### DRB CASE ACTION LOG (SITE PLAN)

DRB Application No.: 03-01433 (P&F)  
Project Name: LANDS OF EARL MONTGOMERY  
Agent: Bohannon Huston Inc.

**CITY OF ALBUQUERQUE  
PLANNING DEPARTMENT  
Development Review Board  
September 3, 2003 Comments**

**RE: Lands of Earl C. Montgomery/Prelim & Final Plat**

ALTA/ACSM LAND PARCEL LANDS OF EARL AND LAND OF EARL C. ALBUQUERQUE, NEW JULY, 2003

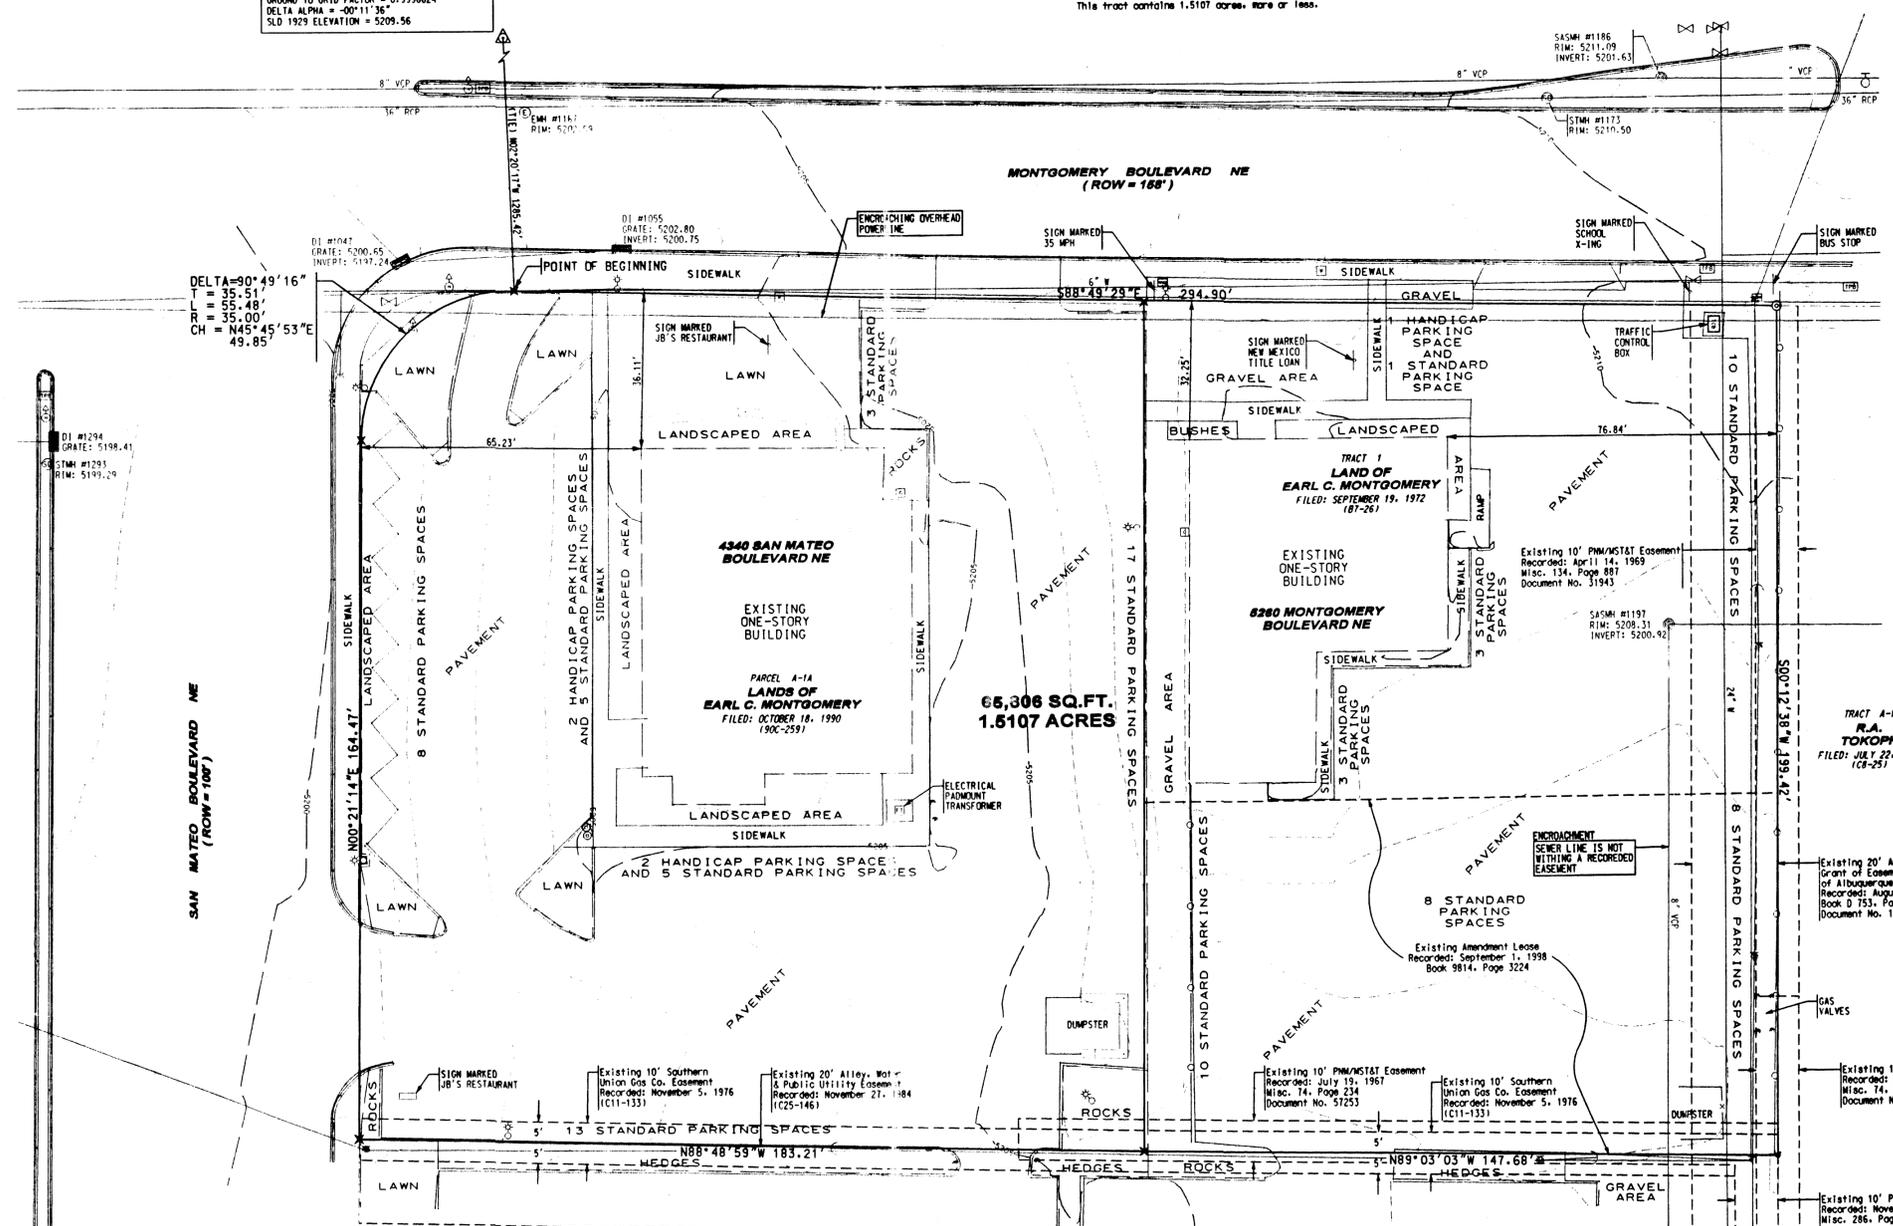
UTILITIES: - provide as-built showing depth of sewer line and  
 dedicate additional public easement for sewer line.  
 \_\_\_\_\_  
 \_\_\_\_\_

<input type="checkbox"/>	10ft from the face of the curb needs to be dedicated as right-of-way.
--------------------------	---

Is existing bldg to be torn down?

The proposed replat appears to place one of the new property lines through the existing building. This condition is not allowable.

to be demolished.  
← T.D. must wait for  
CR & R x 2/2/03
